**Rezoning Transportation Analysis**  
**Petition Number: Insert Zoning Petition #2021-209**  
*General Location Identifier: 20109103*

Revision Log:	Date	Description
	01-24-2022	First Review (KP)
	03-21-2022	Second Review (KP)

**Transportation Summary**

1 REZONING PLAN

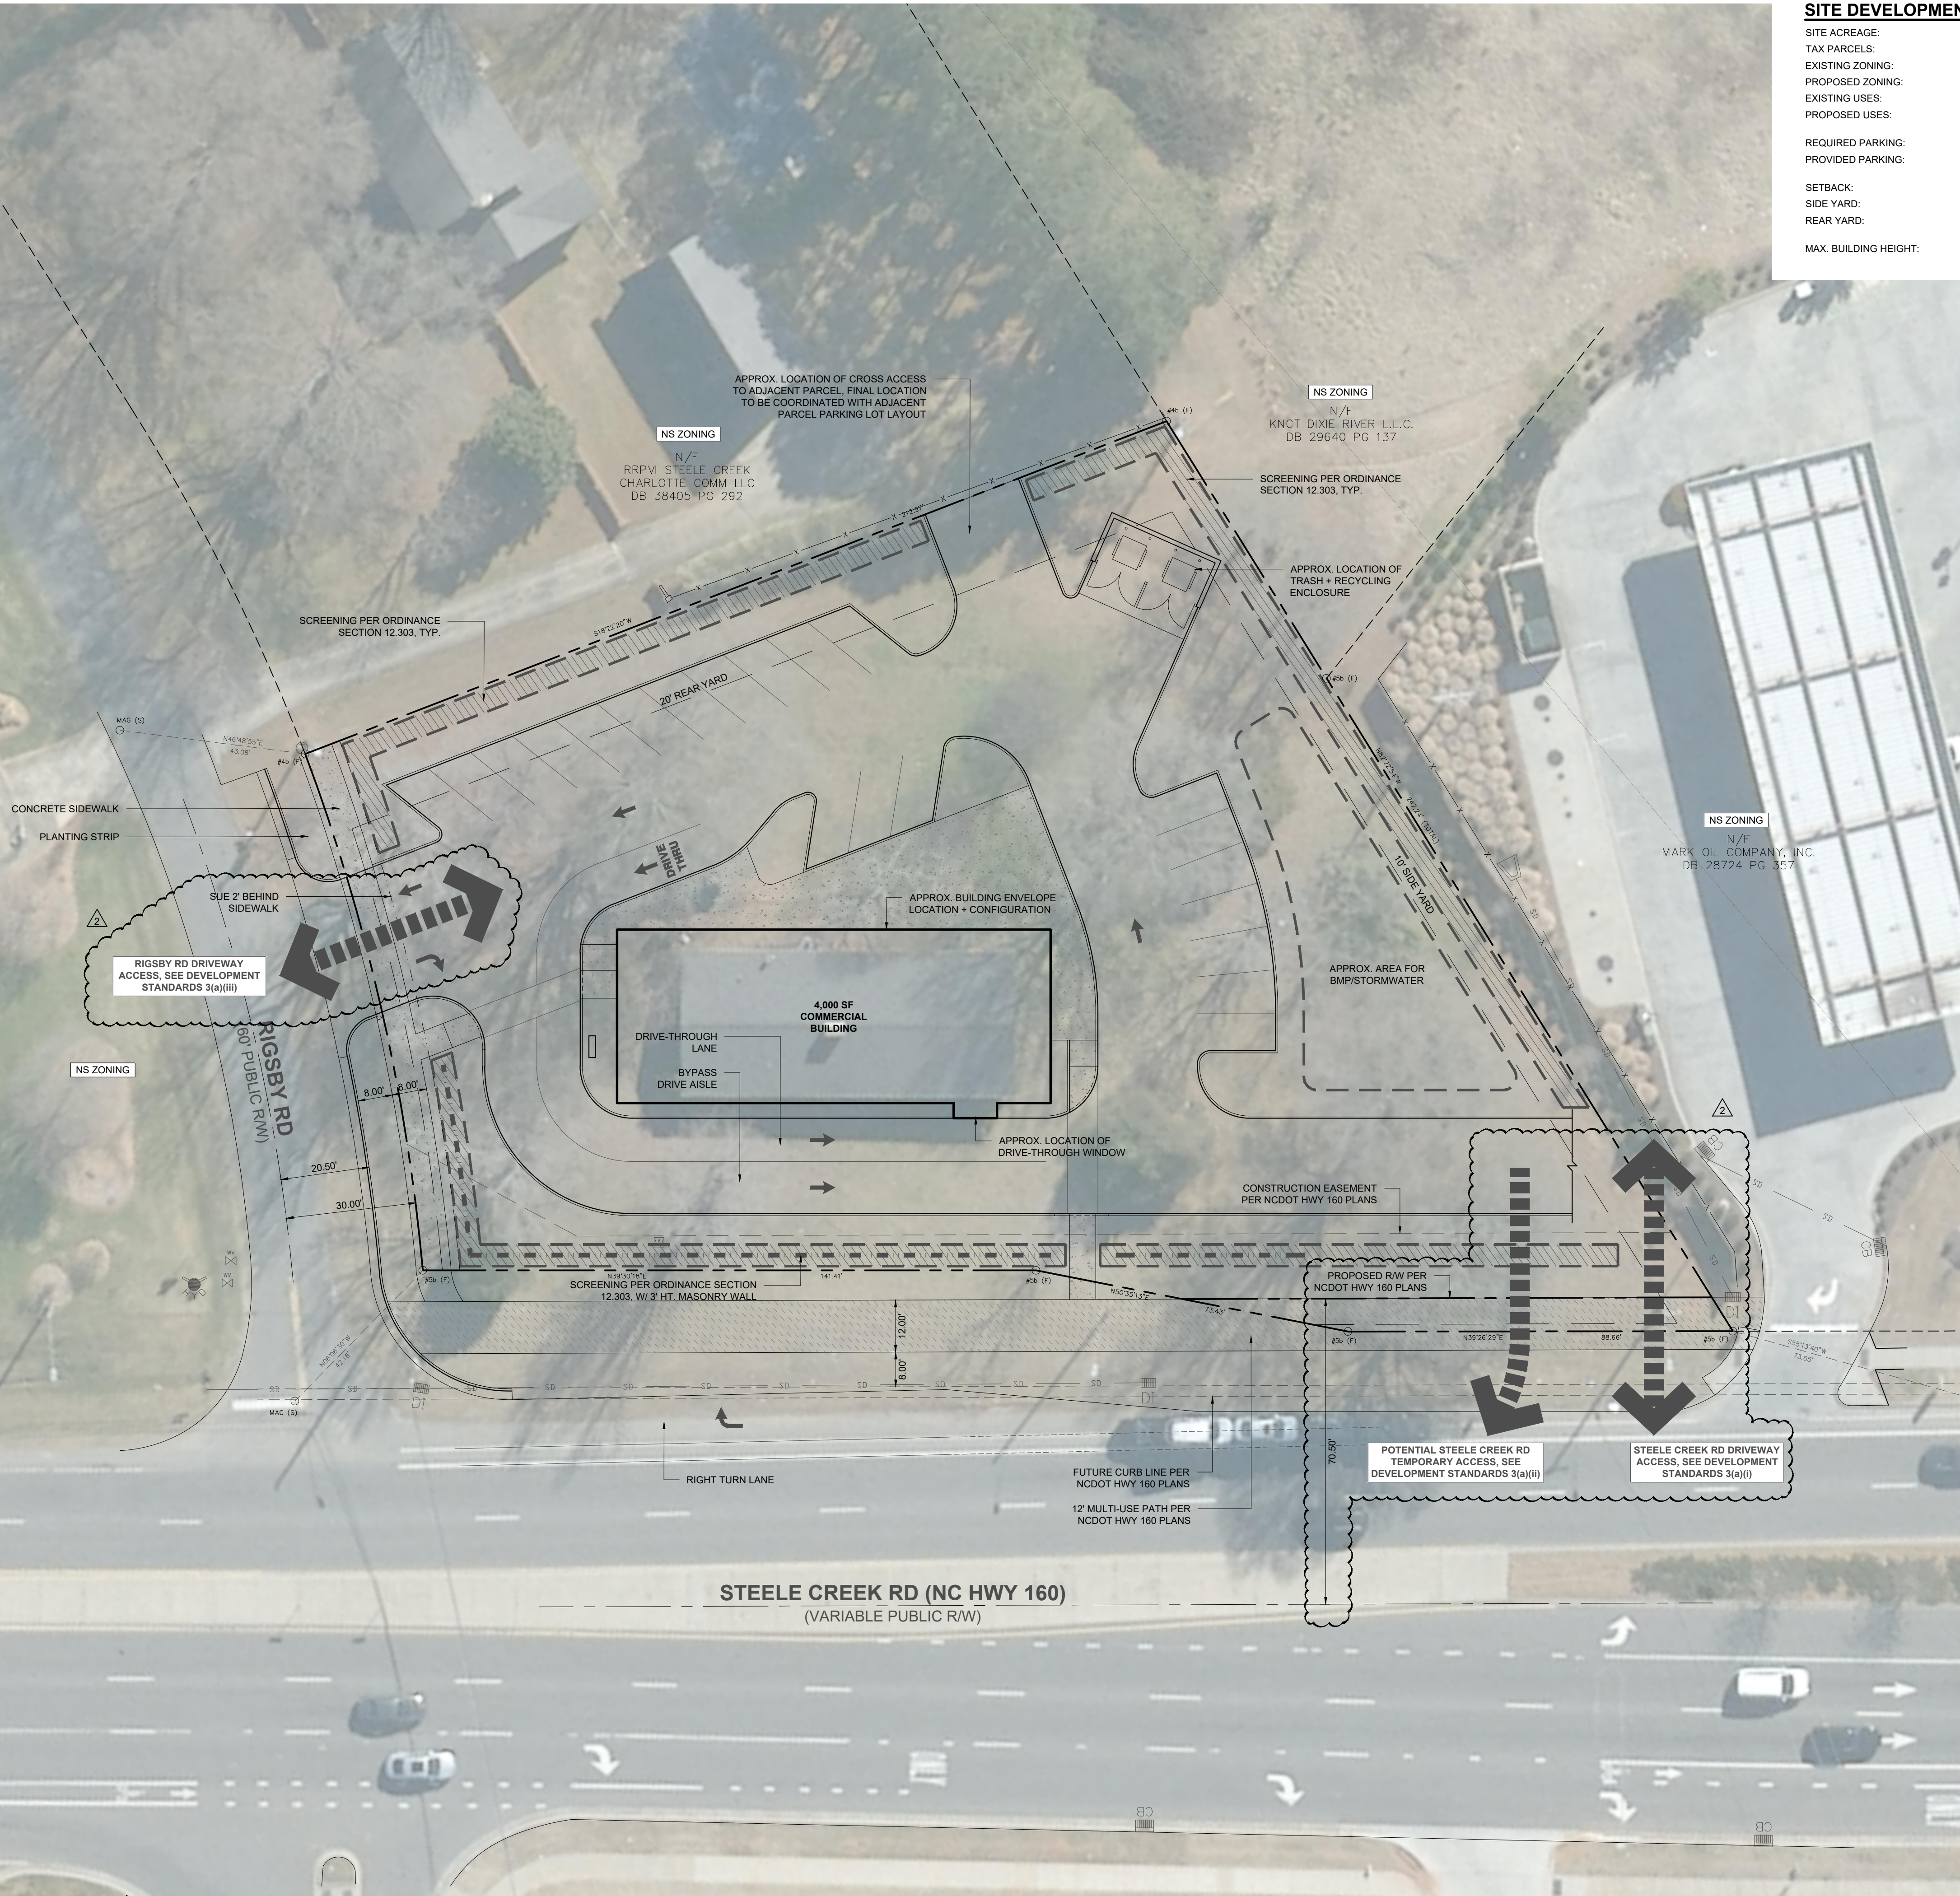
Label and dimension the back of curb and gutter from the existing centerline of each road.

**Outstanding Comment:** The site plan shall label and dimension the right-of-way from each road centerline.

**Update to Comment as a Result of 03-14-2022 Site Plan:** Place a sidewalk utility easement 2-feet behind the sidewalk along Rigsby Road.

- 12. **New Comment as a Result of 03-14-2022 Site Plan:** Revise the conditional notes by committing to provide an access easement, during permitting, with PID 20109114 to allow cross-access as generally shown on the site plan.

- 13. **New Comment as a Result of 03-14-2022 Site Plan:** Revise the site plan by clarifying the 6-foot dimension on the site's frontage of Steele Creek Road.
